**Southern
Water**

Your ref
BN/84/20/PL

Proposal: Application for variation of condition 2 (approved plans) imposed on planning permission BN/93/19/PL for the development of 95 dwellings; and consequential changes to other conditions following commencement of development.

Site: BN/84/20/PL: - Land at Angels Nursery, Yapton Road, Barnham, PO22 0AY.

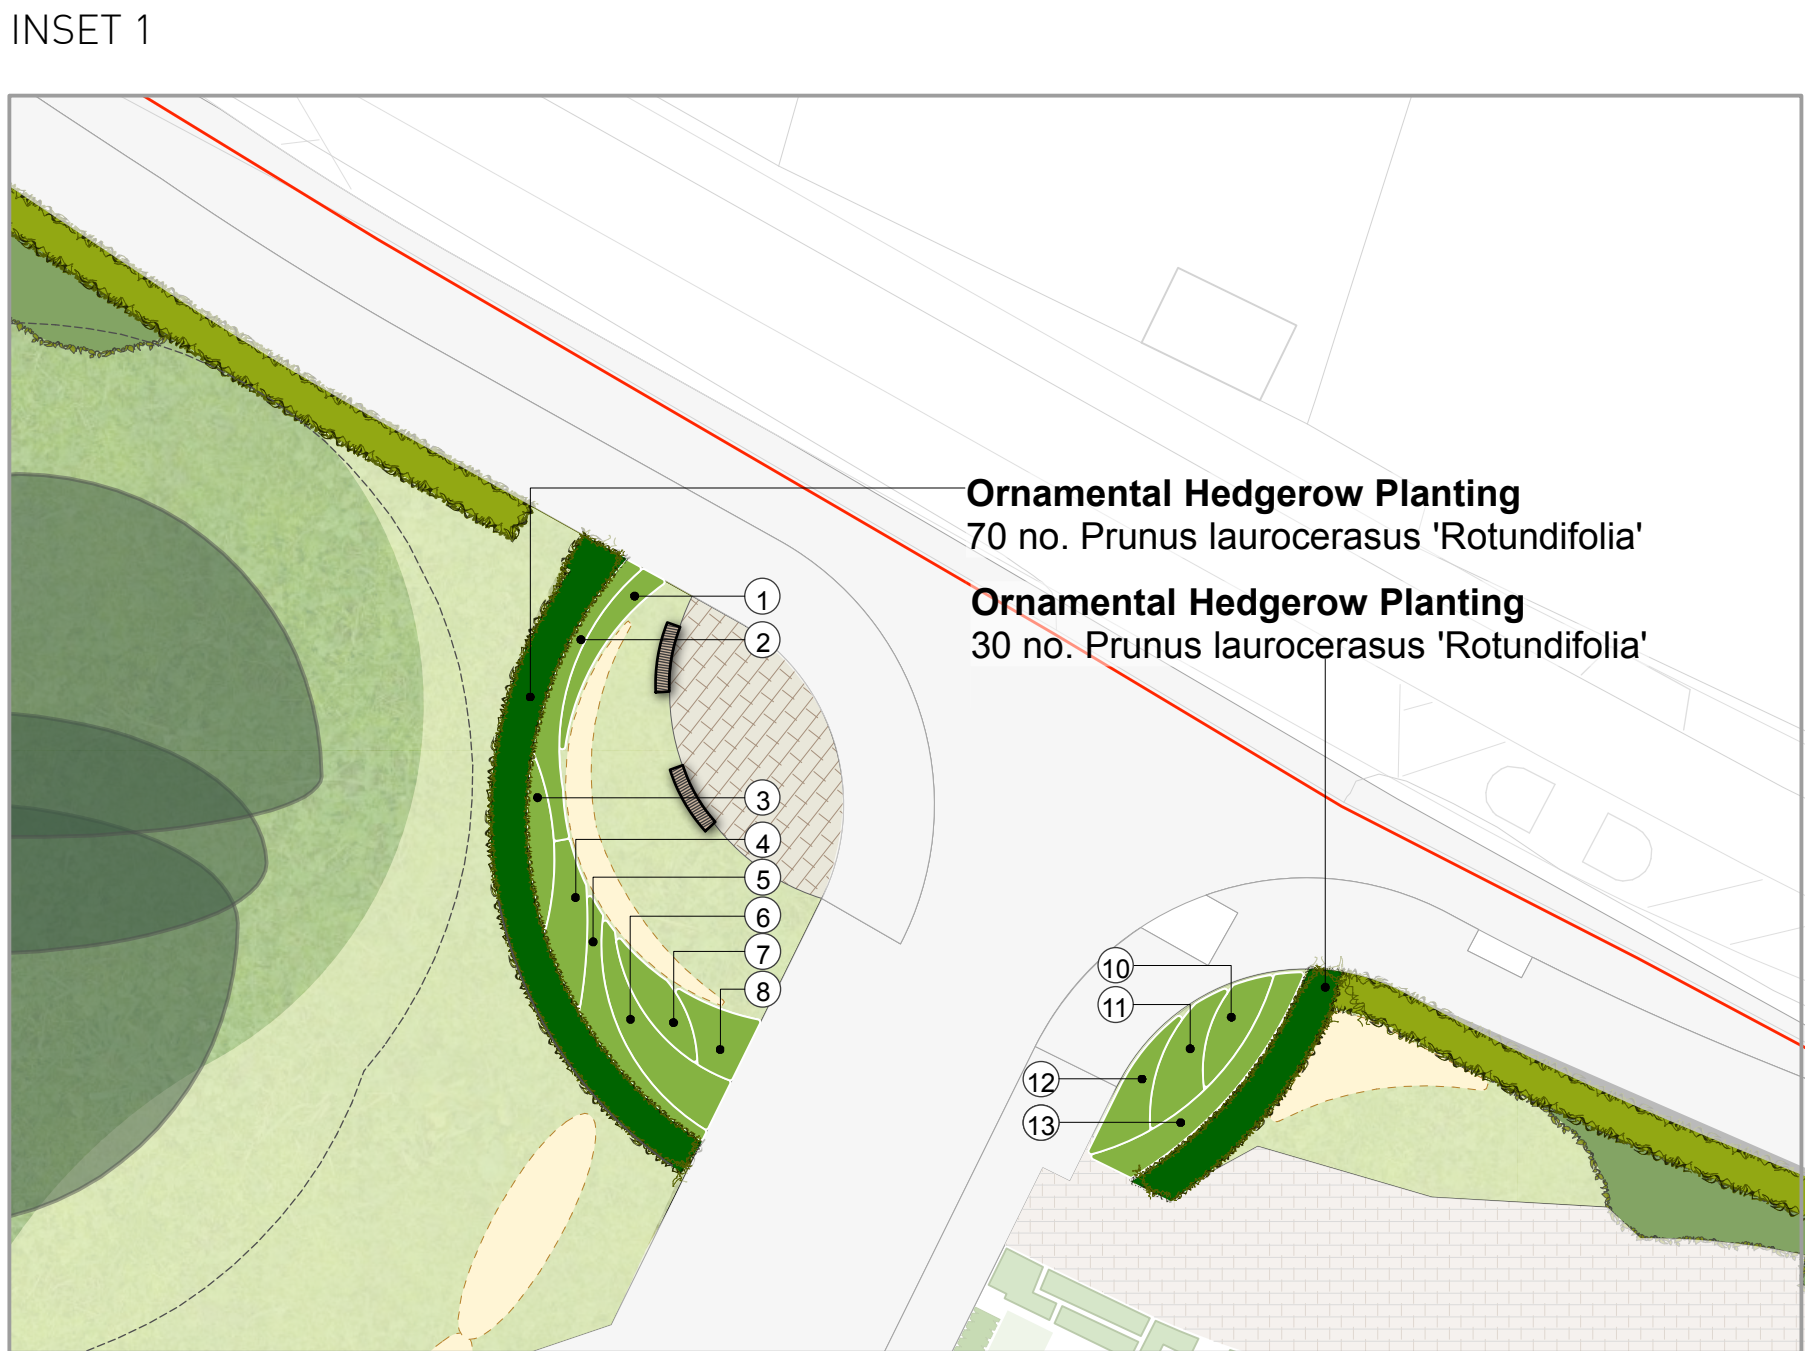
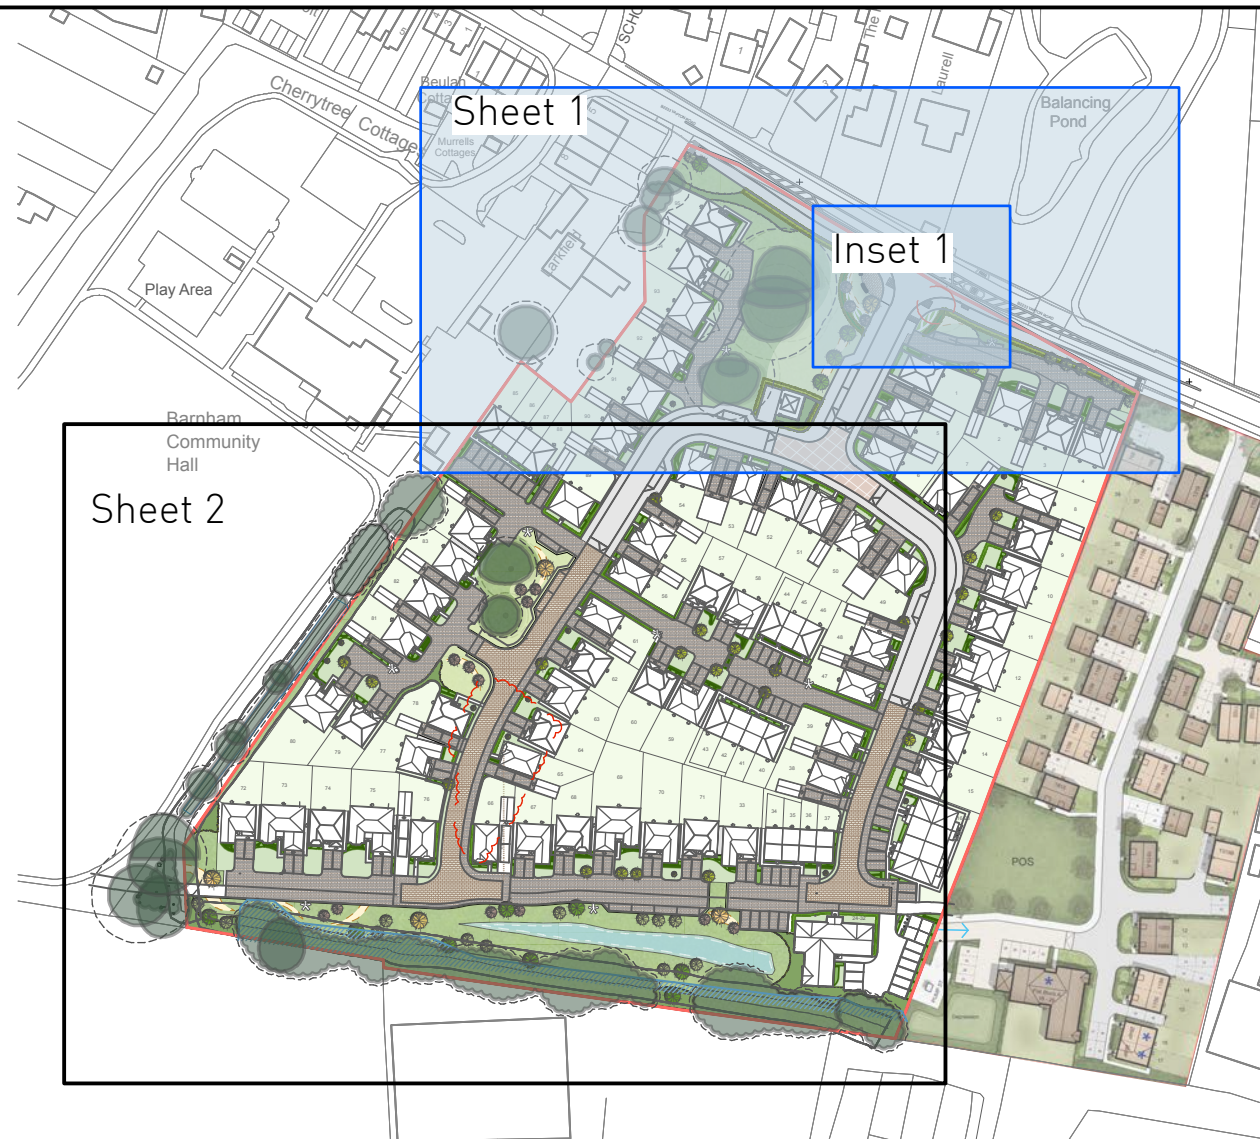
Southern Water has no objections to variation of conditions 02. The submitted plans shows proposed tree planting within standoff distance from public drainage apparatus.

We have restrictions on the proposed tree planting adjacent to Southern Water sewers, rising mains or water mains and any such proposed assets in the vicinity of existing planting. Reference should be made to Southern Water's publication "A Guide to Tree Planting near water Mains and Sewers" (southernwater.co.uk/media/1642/ds-tree-planting-guide.pdf) and the Sewerage Sector Guidance (water.org.uk/sewerage-sector-guidance-approved-documents/) with regards to any landscaping proposals and our restrictions and maintenance of tree planting adjacent to sewers, rising mains and water mains.

No new soakaways, swales, ponds, watercourses or any other surface water retaining or conveying features should be located within 5 metres of a public gravity sewer, rising main or water main.
